PERMITS
BUREAU OF INSPECTION
PAYSON II
This is to certify that WESCOTT & PAYSON dba Development
has permission to Single Family 24 x 36 Colonial w/ attached 12 x 24 garage
AT 130 YALE ST (Lot 8) r persons 438 A018001

ONE AND TWO FAMILY	PLAN REVIEW	CHECKLIST
Soil type/Presumptive Load Value (Table R401.4.1)	Submitted Plan	Findings/Revisions/Dates
Component	Submitted Plan	Findings/Revisions/Dates
STRUCTURAL Footing Dimensions/Depth (Table R403.1 & R403.1(1), (Section R403.1 & R403.1.4.1)	10" x 16" - OK	
Foundation Drainage, Fabric Damp proofing (Section R405 & R406)	Damage not labeled + size	- OK
Ventilation/Access (Section R408.1 & R408.3) Crawls Space ONLY	N/A	
Anchor Bolts/Straps, spacing (Section R403.1.6)	Size of bolt	- OK
Lally Column Type (Section R407)		
Girder & Header Spans (Table R 502.5(2)) Built-Up Wood Center Girder Dimension/Type	Need to show where joint leads from ULS are	OK
Sill/Band Joist Type & Dimensions First Floor Joist Species Dimensions and Spacing (Table R502.3.1(1) & Table R502.3.1(2))	OK	
Second Floor Joist Species Dimensions and Spacing (Table R502.3.1(1) & Table R502.3.1(2))	2x10 - 16" oc	OK

Address: 130 Yale St. (Lot 8)

CHECK-LIST AGAINST ZONING ORDIN

1st Floor Plan

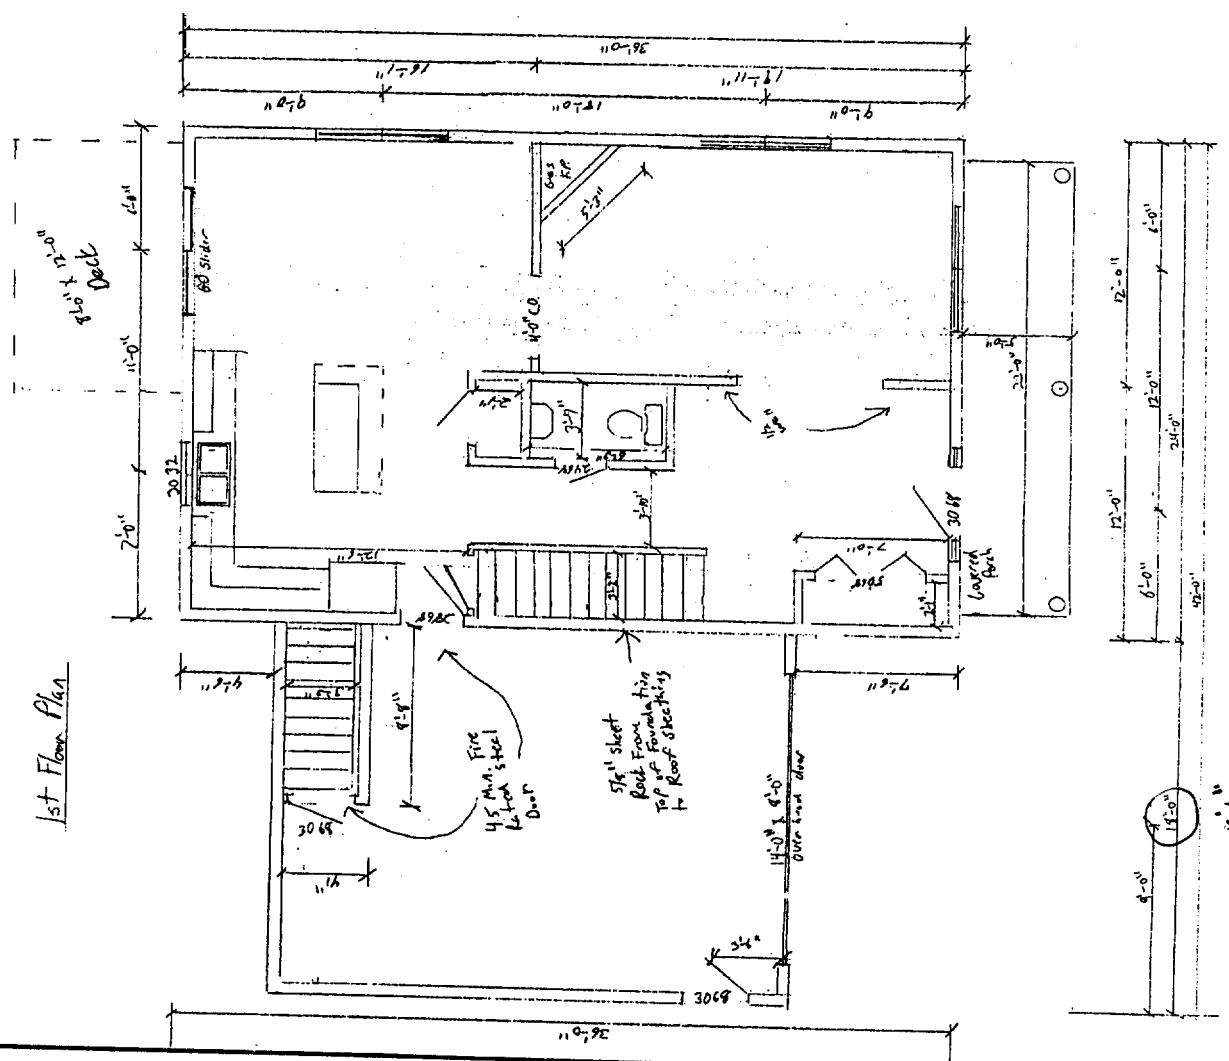
Smoke Detectors (Section R313)
Location and type/Interconnected *Not shown*

STAIR RAIL DETAIL

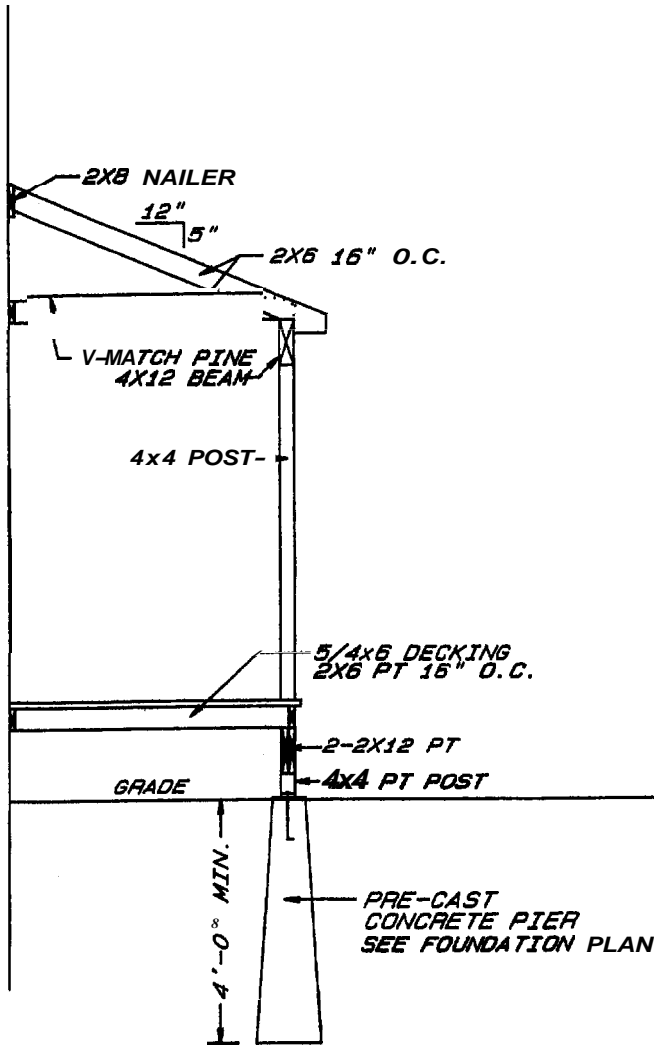
Guardrails and Handrails *OK* *See elevation*

PORCH DECK DETAIL

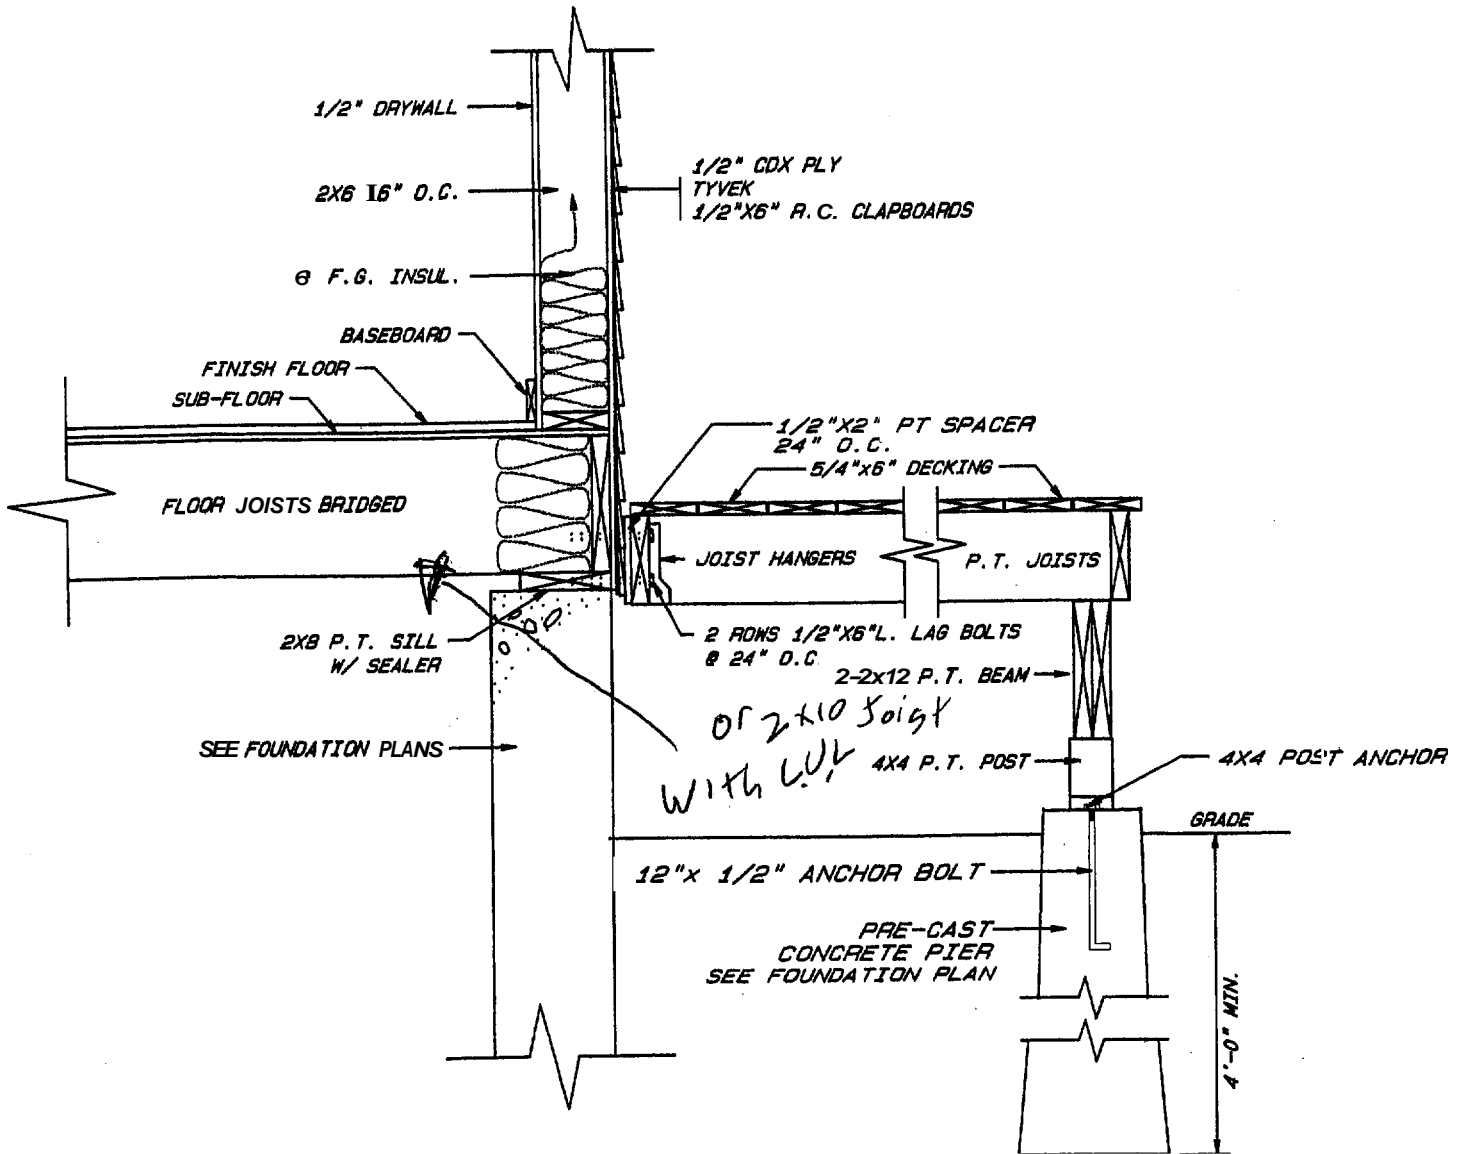
Deck Construction (Section R502.2.1) *Front - Need header + Frost protection + deck framing*

Bar - need 4" Piers + Girder size for deck + ledger detail.
